22nd August 2024

H19-0329-24 – Tydd Solar –Response to Statutory Consultees: LCC Highways Comments

I am writing you on behalf on my client, Pathfinder Clean Energy UKDev Ltd, regarding the above application for a proposed development of a ground-mounted solar array at Land East of Guanockgate Road, Sutton St. Edmund, Spalding, Lincolnshire PE13 4PL. Thank you for providing us the opportunity to respond further to comments from LCC Highways received on 11th June 2024.

Off-site Junction Location Plan

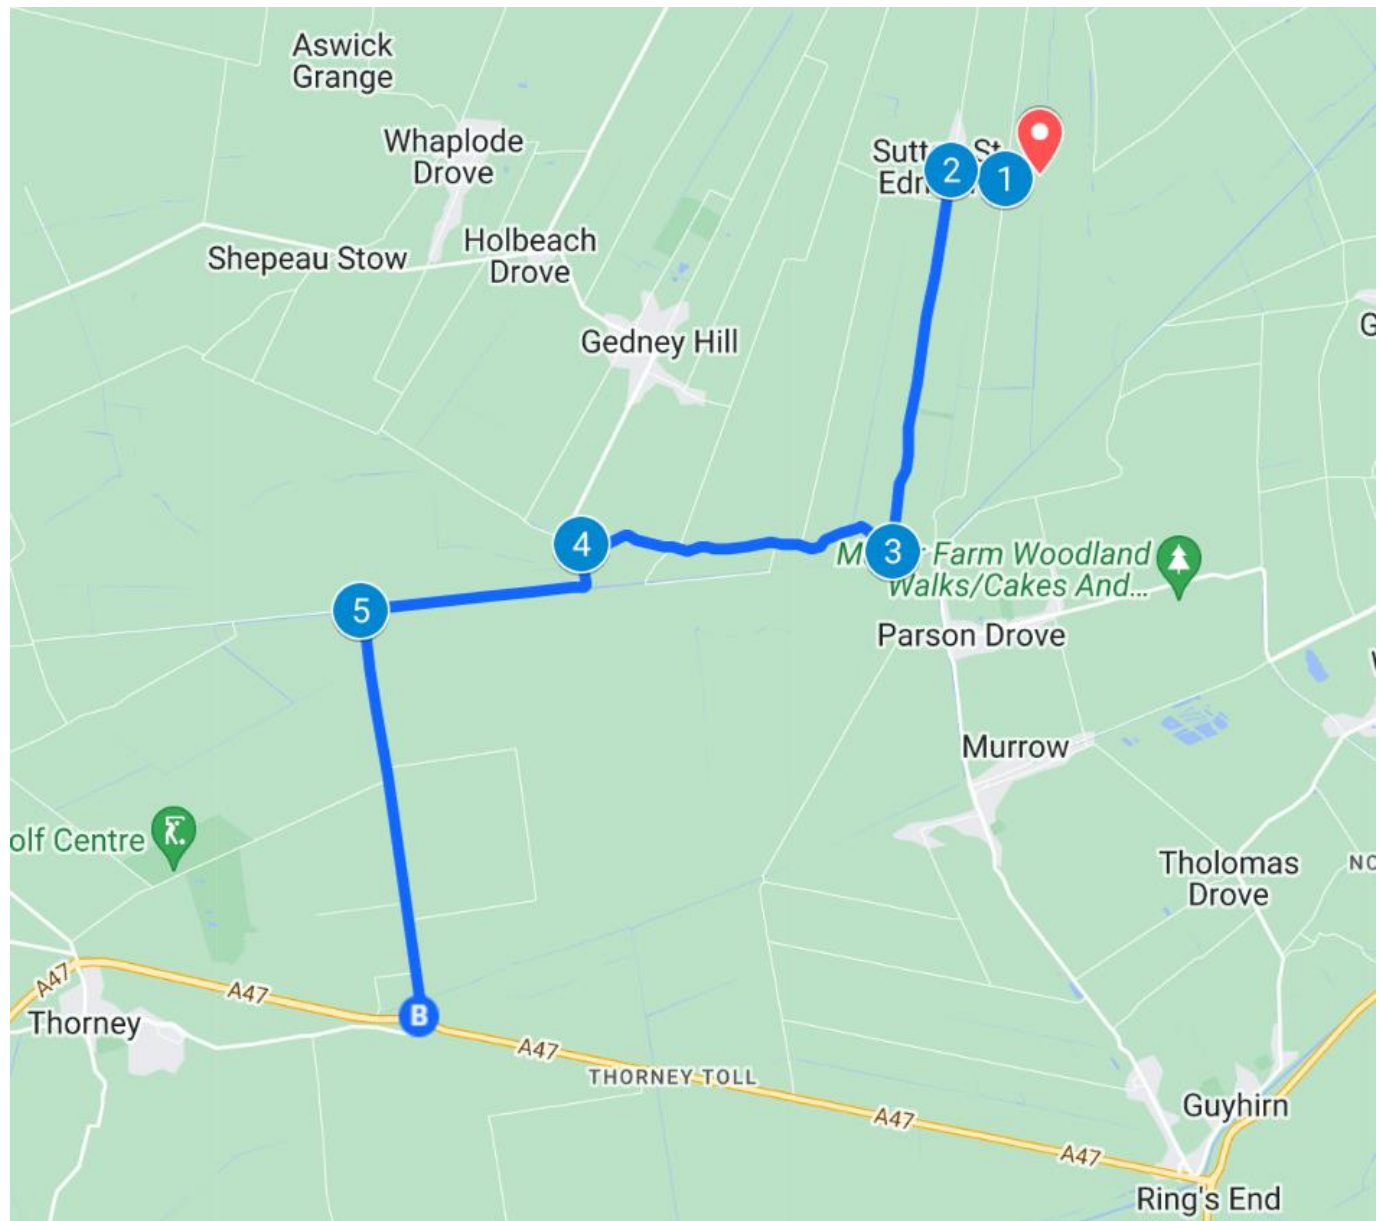
A swept path analysis for the turning movements of HGV's are to be provided in both directions for the following junction assessments:

- *The B1161 with French Drove*
- *The B1166/Old South Eau Drove with the B1167/French Drove*
- *The B1166/Old South Eau Drove with Broadgate*
- *Broadgate with Cross Road*

As requested by LCC, additional Swept Path Analysis has been undertaken at the five junctions (four off-site and the site access) located along the proposed construction route as identified by LCC (as shown in Appendix C). This is in addition to the analysis included within the submitted Transport and Access Statement (TAS). The analysis shows a 16.5m long articulated HGV accessing and egressing these locations, which is considered the largest vehicle required to access the site during the construction and decommissioning phases. The analysis for each junction can be found in Appendices D - H.

The findings show that these junctions can accommodate the 16.5m long articulated HGV (referred to as articulated HGV) travelling in both directions. However, the majority of construction vehicles are likely to be rigid HGVs of up to 10m in length, which are capable of transporting all construction materials and components. Only the BESS units and substation components are likely to require transportation by larger articulated vehicles of up to 16.5m in length. These vehicles have been considered as part of the construction routing analysis presented within the TAS.
